Please see response from Private Sector Housing below.

**APPLICATION NO:** BR/91/20/PD

**Site Address:** 1 Sudley Road Bognor Regis PO21 1EJ

**Description of Works:** Prior notification under Schedule 2, Pat 3, Class M for the change of use from mixed use A1 & C3 to C3 only to create 1 bed house.

Proposed Plans and Elevations
Planning

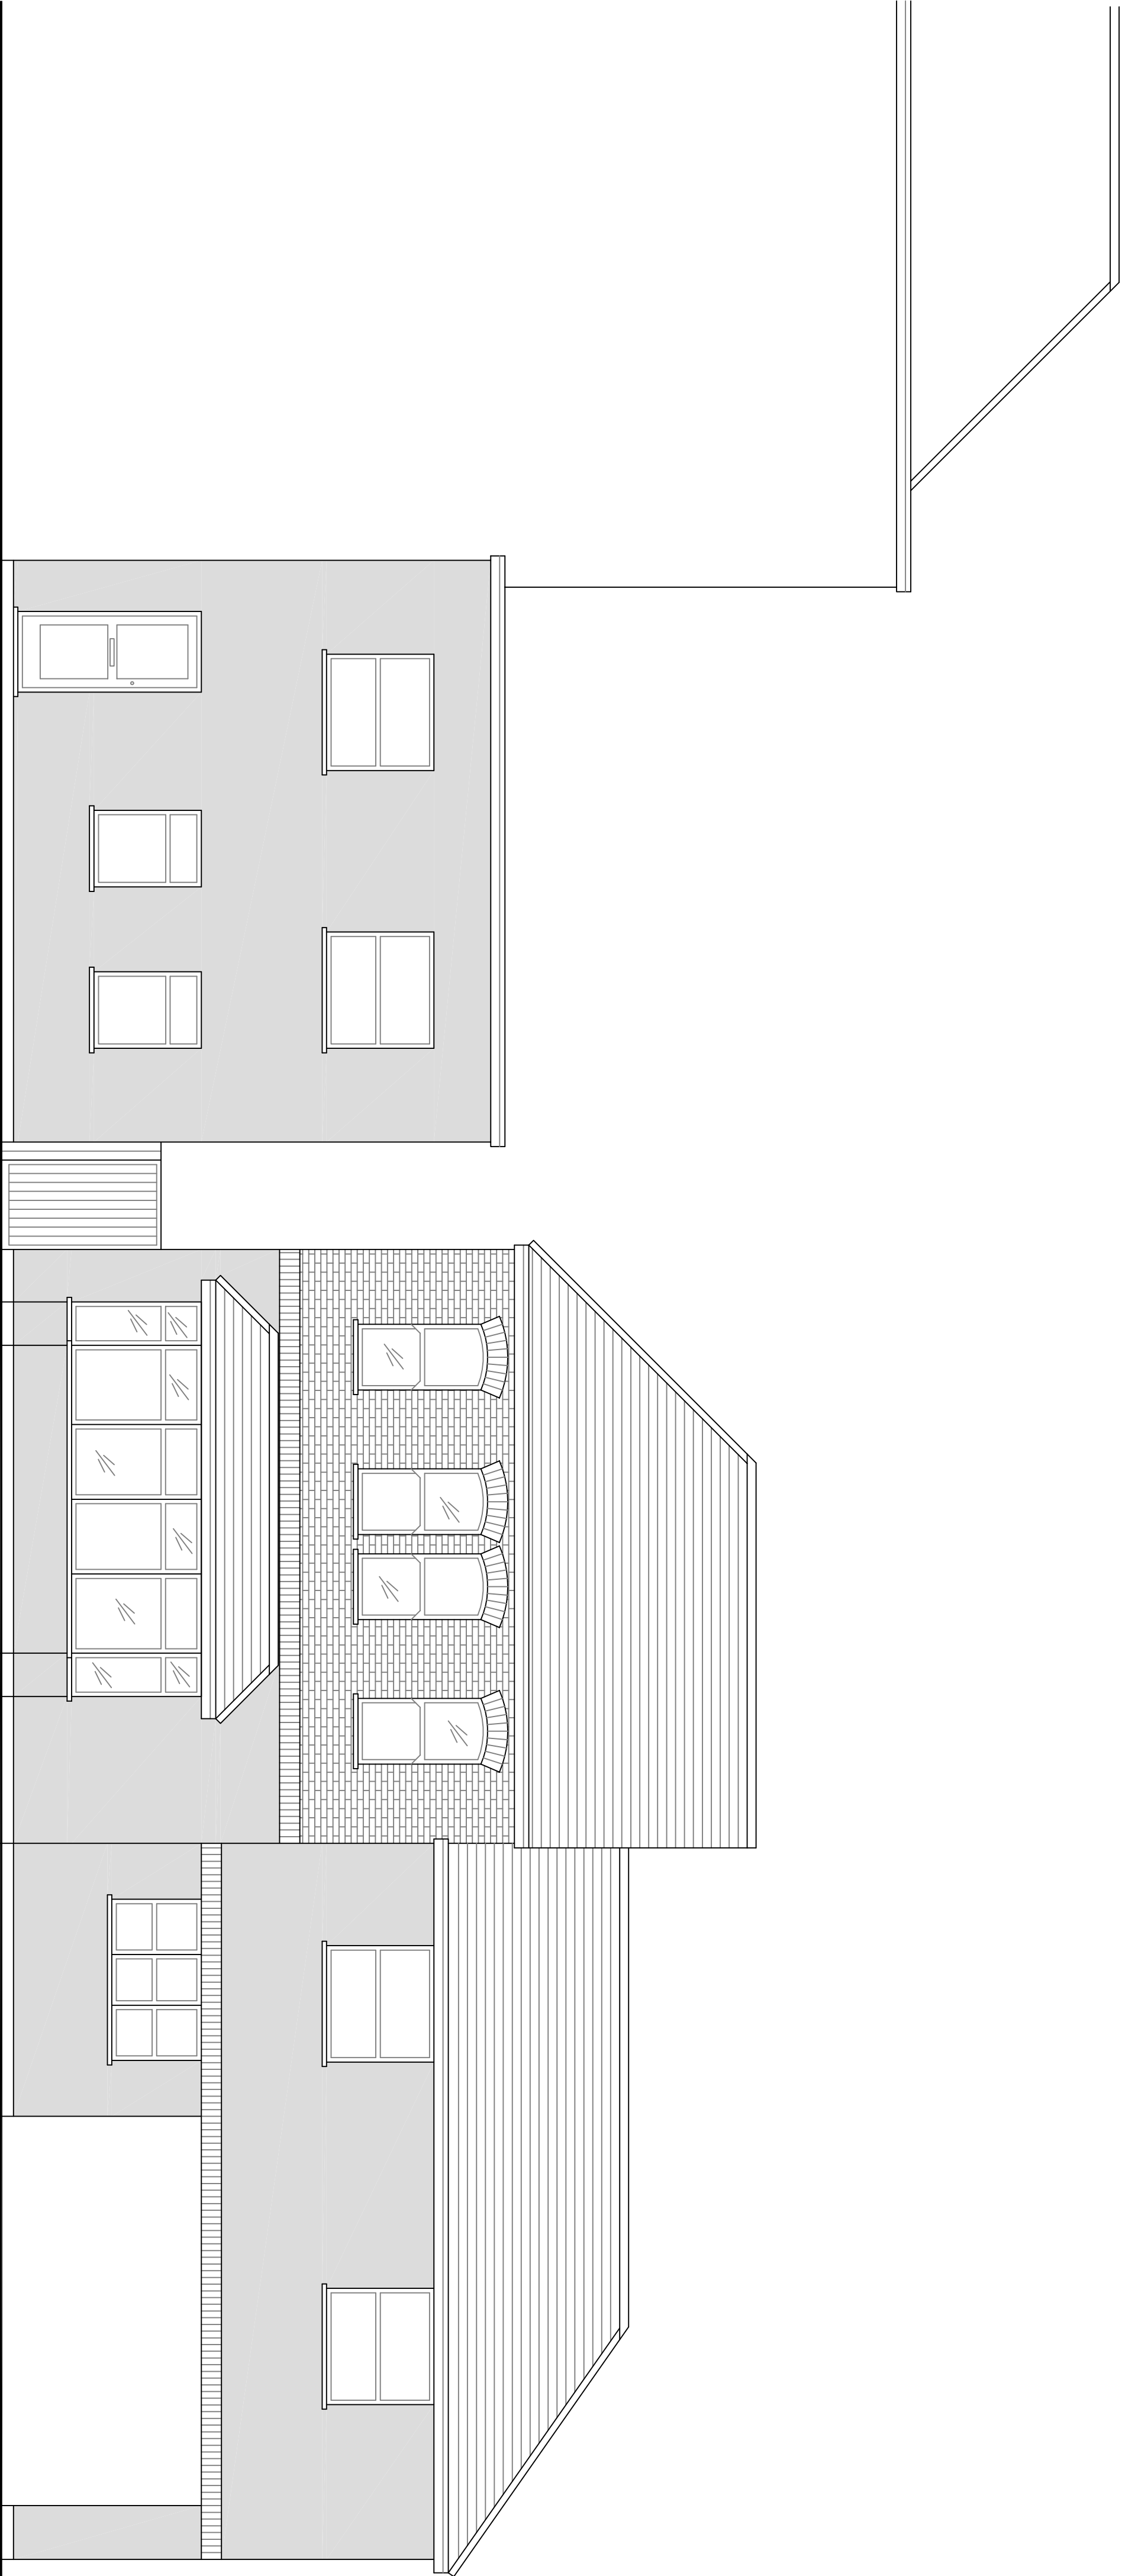
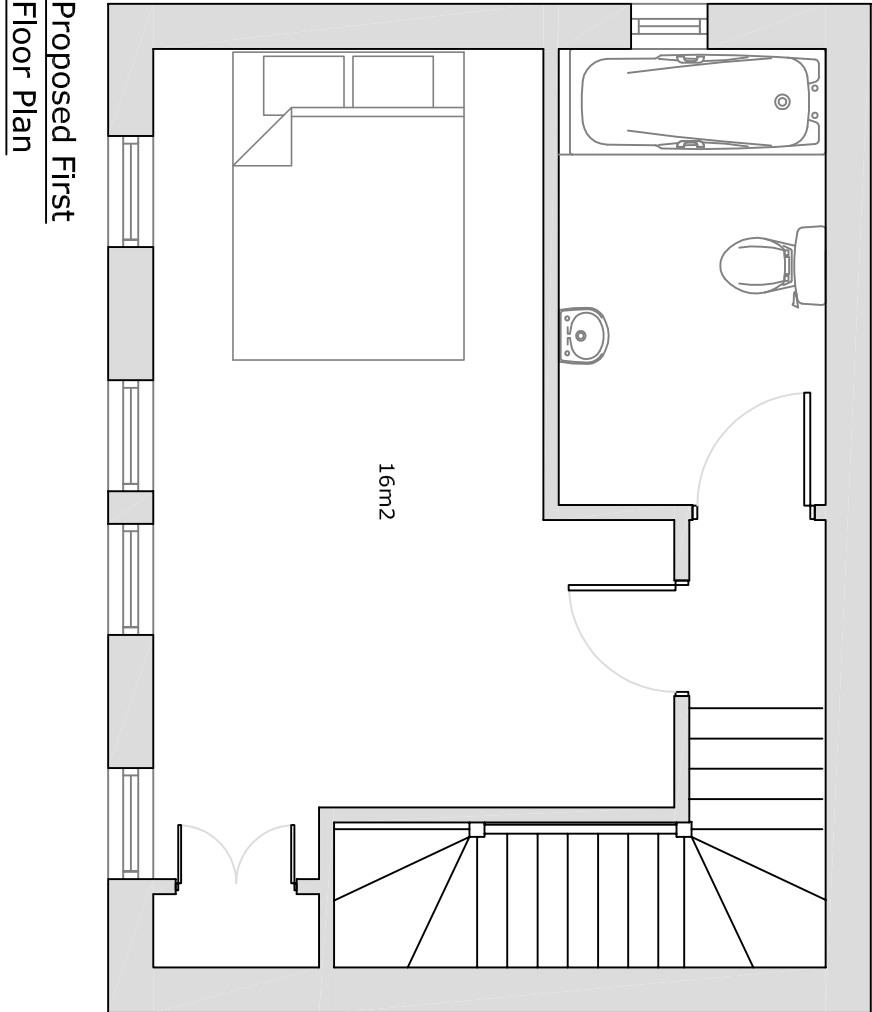
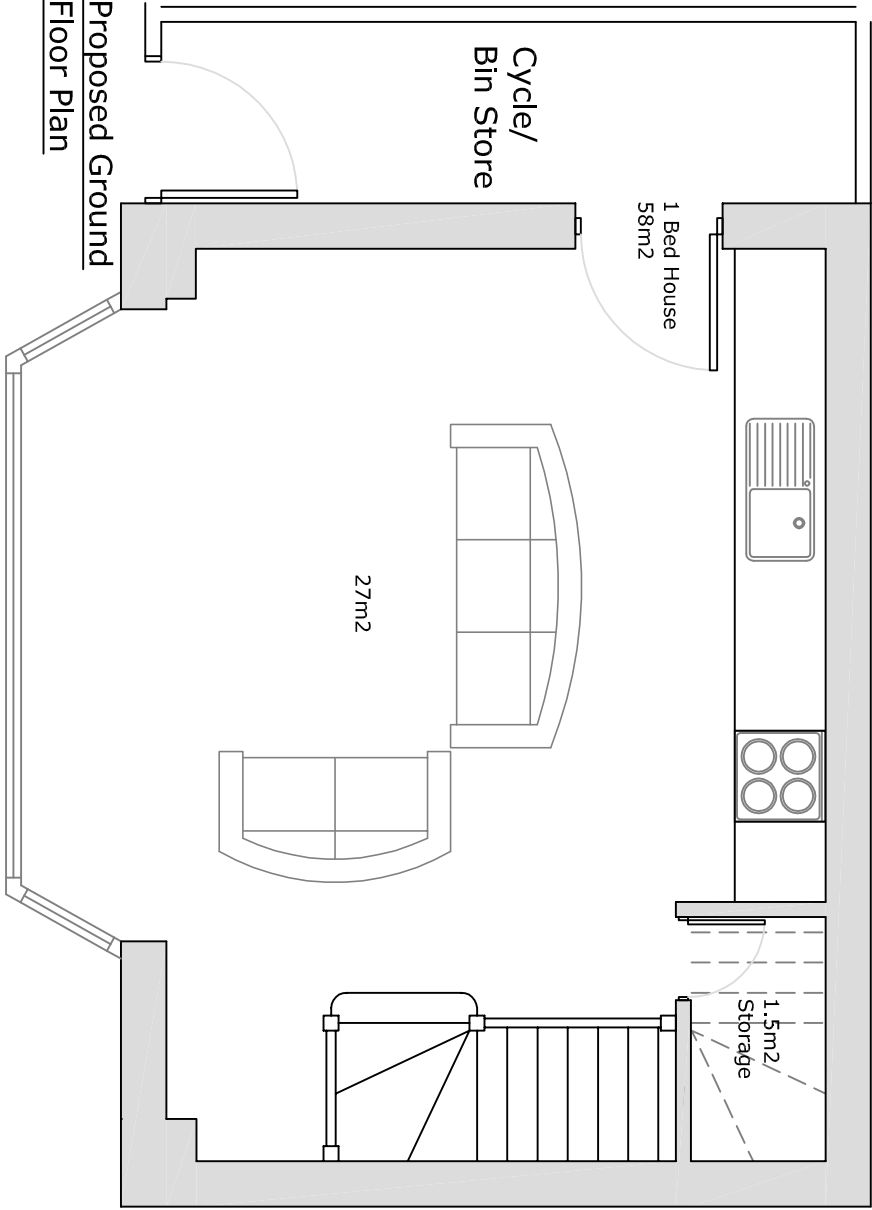
- Appropriate fire precaution facilities and equipment must be provided of such type, number and location as are considered necessary. Guidance on fire safety is contained in the LACORS guidance document – “Housing – Fire Safety, Guidance on fire safety precautions for certain types of existing housing”
- If renting the property; Grade D1, LD2 system:
  - o interlinked mains wired smoke alarms with integral tamper-proof battery back-up located throughout the escape route
  - o Interlinked mains wired smoke alarm with integral tamper-proof battery back-up within the lounge/kitchen area\*\*
  - o Fire blanket to be provided in the kitchen area

\*\* It is usually more common to have a mains wired heat detector with integral tamper-proof battery back-up sited within the kitchen area as this avoids false alarms when cooking food. However, as the escape route from the first floor passes through the open plan lounge/kitchen and this will be a single household dwelling, I believe a smoke detector would be more appropriate as it would alert the sleeping occupant(s) more quickly in the event of a fire. A fire would need to be more developed to set off a heat detector which, in this instance, could hinder a safe escape from the property.

- If owner occupier; Grade D2, LD2 system:
  - o interlinked mains wired smoke alarms with integral user-replaceable battery back-up located throughout the escape route
  - o Interlinked mains wired smoke alarm with integral user-replaceable battery back-up within the lounge/kitchen area\*\*

\*\* It is usually more common to have a mains wired heat detector with integral user-replaceable battery back-up sited within the kitchen area as this avoids false alarms when cooking food. However, as the escape route from the first floor passes through the open plan lounge/kitchen and this will be a single household dwelling, I believe a smoke detector would be more appropriate as it would alert the sleeping occupant(s) more quickly in the event of a fire. A fire would need to be more developed to set off a heat detector which, in this instance, could hinder a safe escape from the property.

- As the escape route passes through the open plan lounge/kitchen and egress from the property is closer to the kitchen area, consideration should be given to installing an escape window either within the bedroom or within the lounge. An escape window should only be installed if the following criteria can be met:
  - o They serve rooms whose floor level is no more than 4.5m from the ground;
  - o Every room served by the escape window has access to it without entering another habitable room;
  - o If it is necessary to pass through the escape route to reach the window, consideration should be had to the travel distance involved;
  - o Occupiers are able-bodied individuals who can reasonably be expected to exit via the window unaided;
  - o There is no basement well or other encumbrance beneath the window such as railings or a conservatory;

- The escape window is openable from the inside without the need for a key and the ground below is level and free of obstructions; and
- The window should lead to a place of ultimate safety

Alternatively, another option could be to leave the front door in place, currently situated at the front of the building.

- Kitchens should have adequate mechanical ventilation
- Mechanical extraction should be provided to all bathrooms/shower rooms/en suites
